## **FIRE RISK MANAGEMENT, INC**

# **Memo Report**

**From:** W. Mark Cummings, P.E.  
**To:** Mr. Bill Hopkins; Archetype Architects  
**Subject:** **Fire Protection & Life Safety Code Review of the Maine Wharf Restaurant Building**

total occupant load = 228
Occupant load, exit, and standpipe diagram

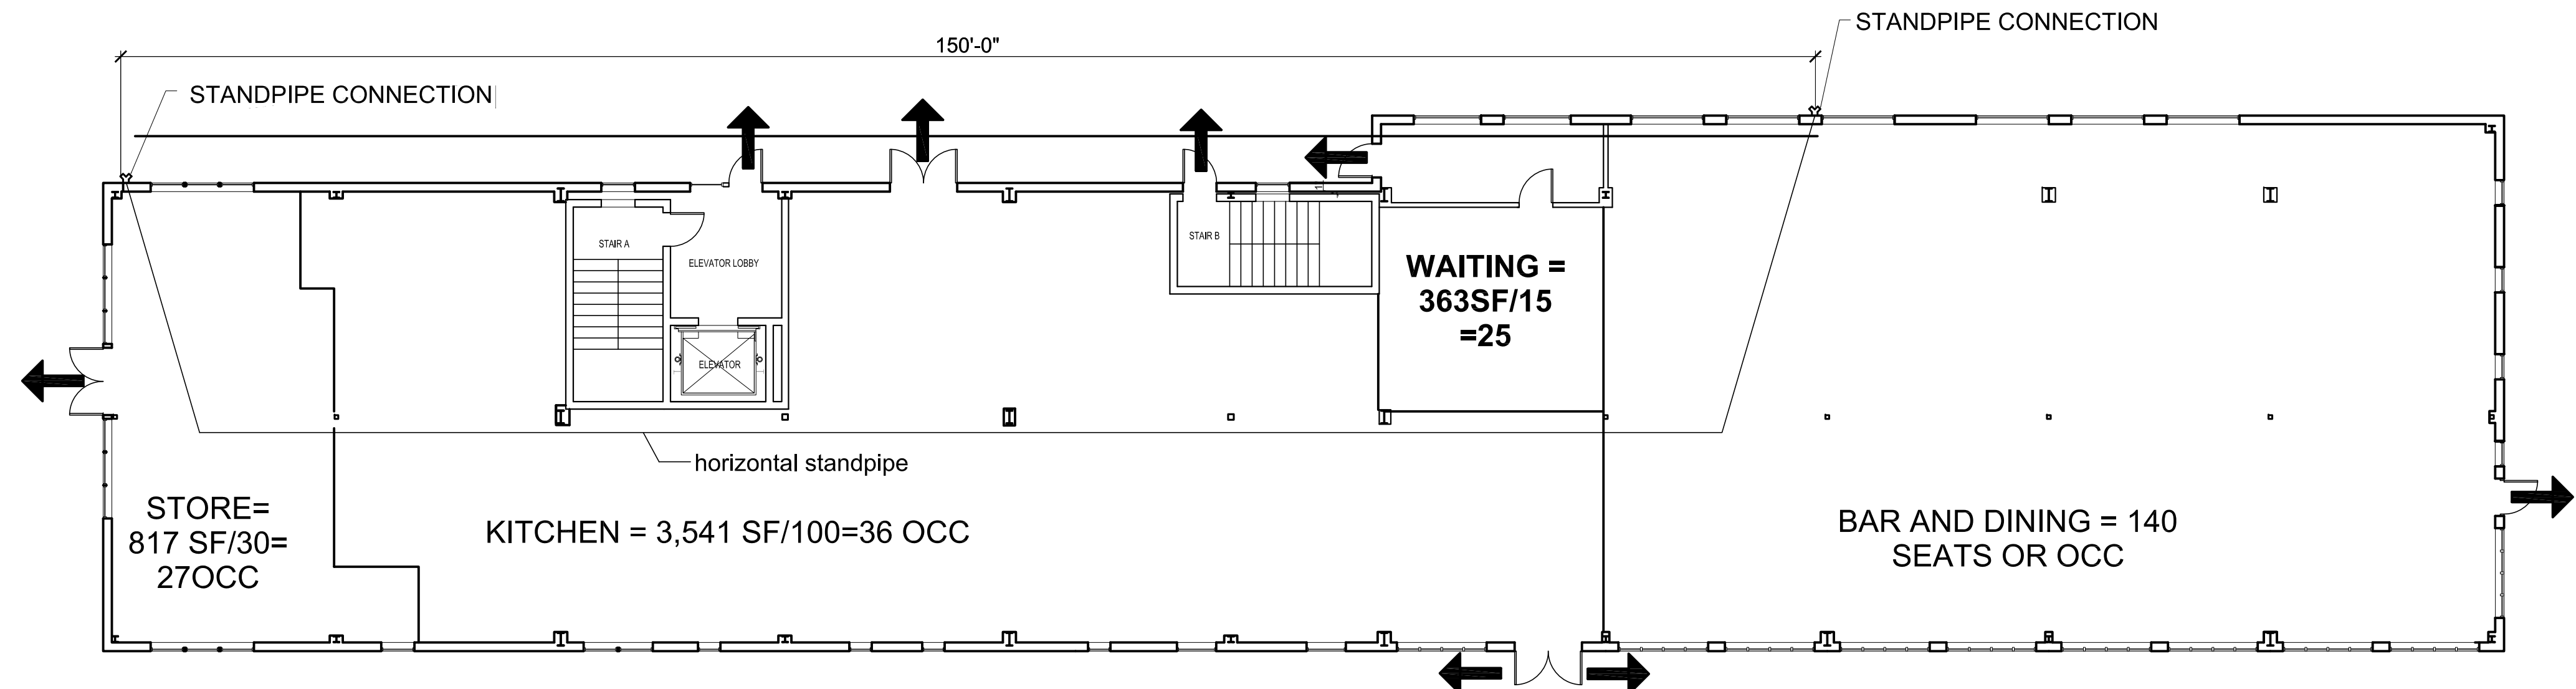
259 persons on the 1<sup>st</sup> floor and 91 persons on each of the 2<sup>nd</sup> and 3<sup>rd</sup> floors. Occupant load is based on the occupant load factors outlined in NFPA 101, Table 7.3.1.2 and MUBEC Table 1004.1.

Required: Two (2) per floor, Provided: Six (6) for the first floor and two (2) for each of floors 2 and 3.

The existing exits have sufficient capacity for up to 1,500 persons on the 1<sup>st</sup> level and approximately 260 persons for each of the 2<sup>nd</sup> and 3<sup>rd</sup> floors; whereby the stairs are the limiting factor for the upper floors. The egress capacity provided for the building greatly exceeds the minimum required capacity needed to support the occupant loads.

Based on the requirements for a main entrance in an Assembly occupancy, the main entrance capacity should represent at least 1/2 of the entire occupant load (NFPA 101 § 12.2.3.6.2). Although not specified on the plans, it appears that the smaller, east door will be the main entrance to the restaurant (assembly) area due to its proximity to what appears to be a reception desk. This single door can accommodate up to 1/2 of the occupant load for the assembly space and, therefore, is compliant.

Distance Limitations: Dead end corridor: Allowed up to 20 ft per NFPA 101 § 12.2.5 and MUBEC 1018.4 for Assembly occupancies and up to 50 ft for Business occupancies per NFPA 101 § 38.2.5 and MUBEC. There are no dead-end corridors exceeding the limitations within the building.

1 | FIRST FLOOR FIT UP PLAN  
 1/8"=1'-0"

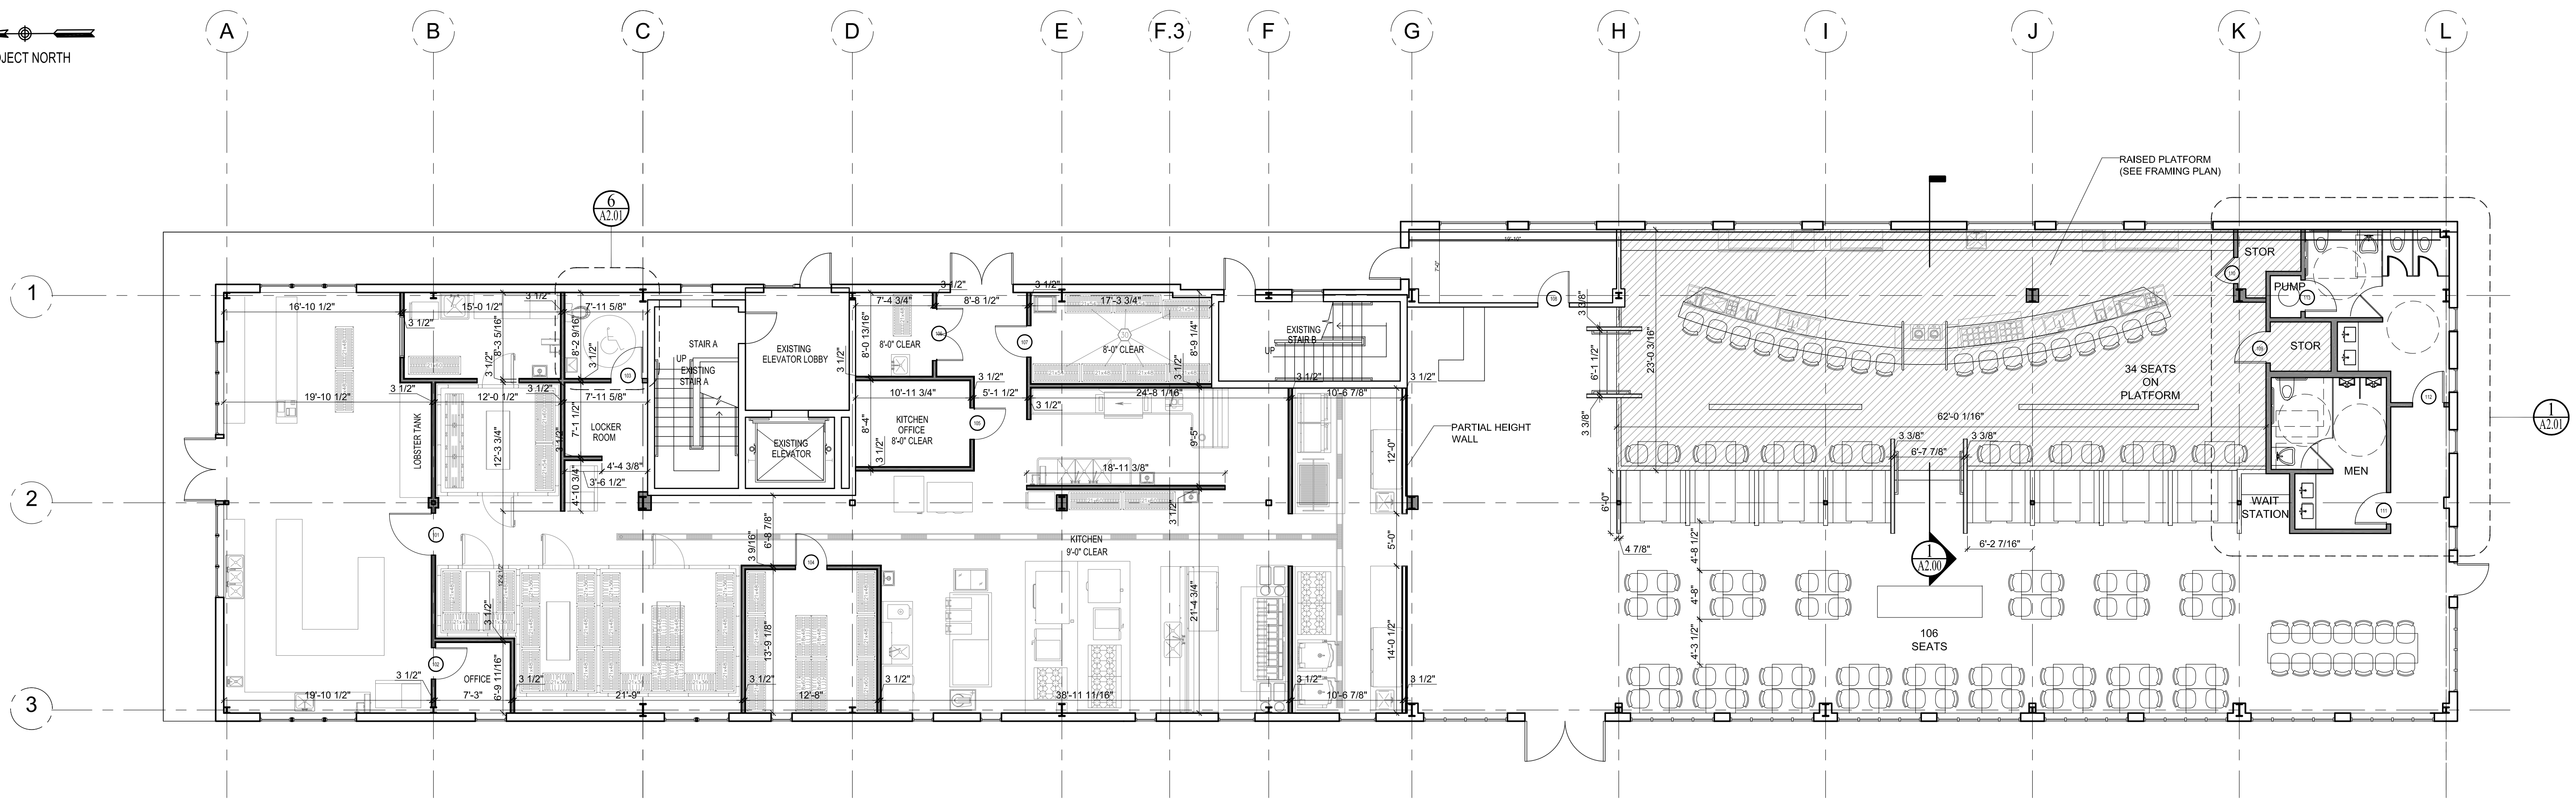
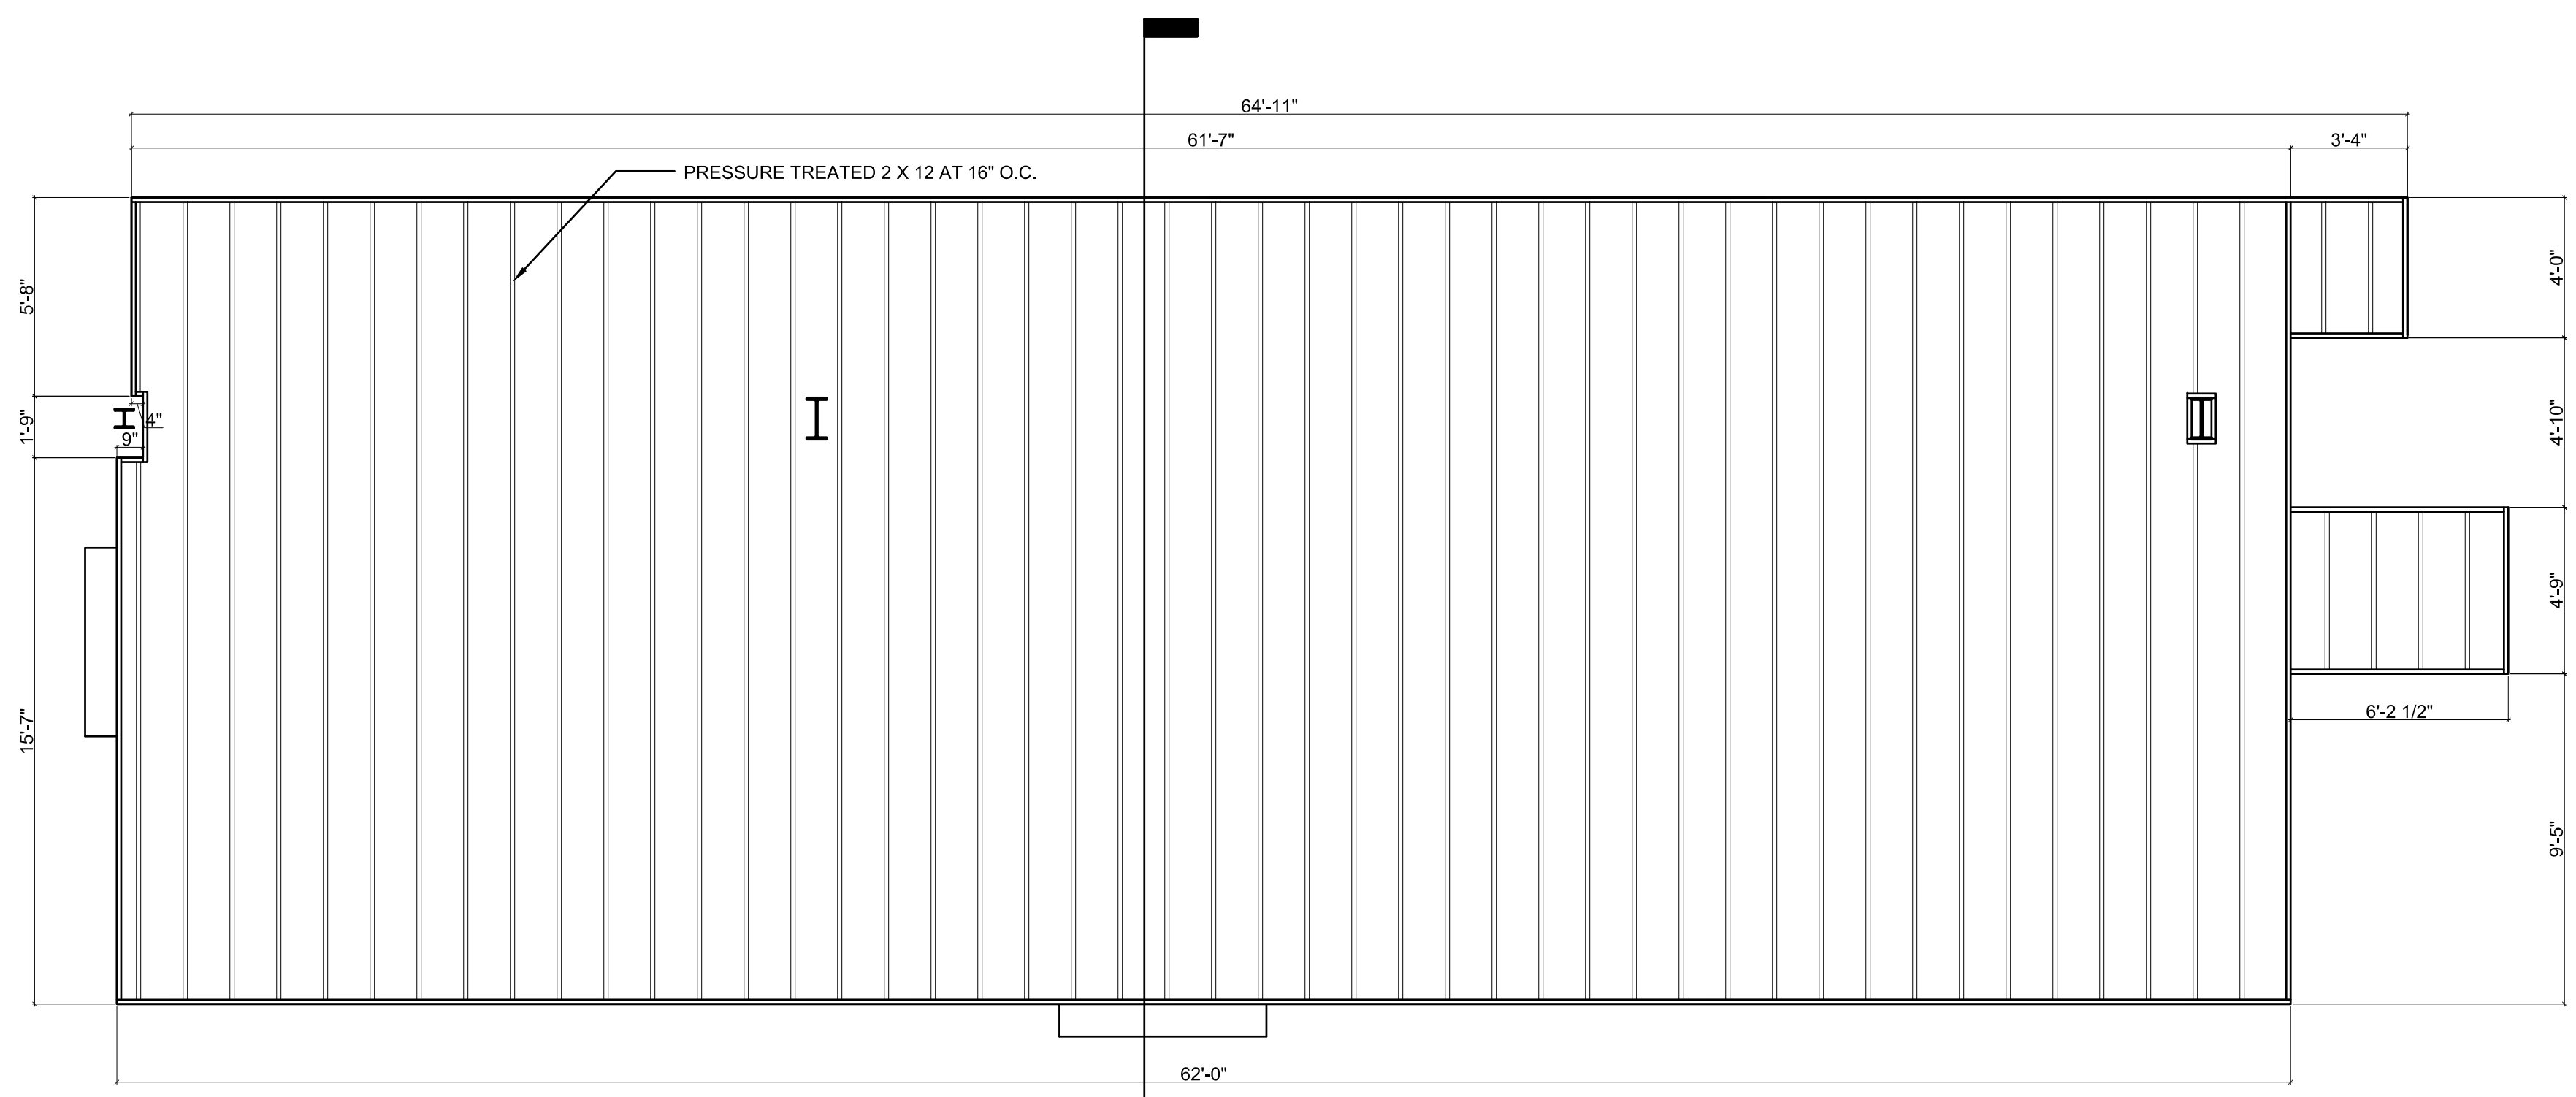
A minimum of two (2) means of egress are required from all floors / areas of the building per NFPA 101 § 7.4.1.2. The 1<sup>st</sup> floor of the building is provided with six independent means of egress leading from the interior of the building directly to the exterior. Where the occupant load of a room or space exceeds 50 people, two independent, remote means of egress are provided from all rooms or spaces. The two upper floors currently have no interior walls defined, but each has access to the two enclosed stairs.

NFPA 101 requires that the exits be adequately separated from one another. For buildings that are protected throughout by automatic sprinkler systems, this separation distance must be equal to or greater than one-third the diagonal dimension of the building. The diagonal dimension was measured at approximately 186 ft. The two stairs on the upper floors are separated by a distance of approximately 68 ft. As such, the separation distance for the exits is compliant.
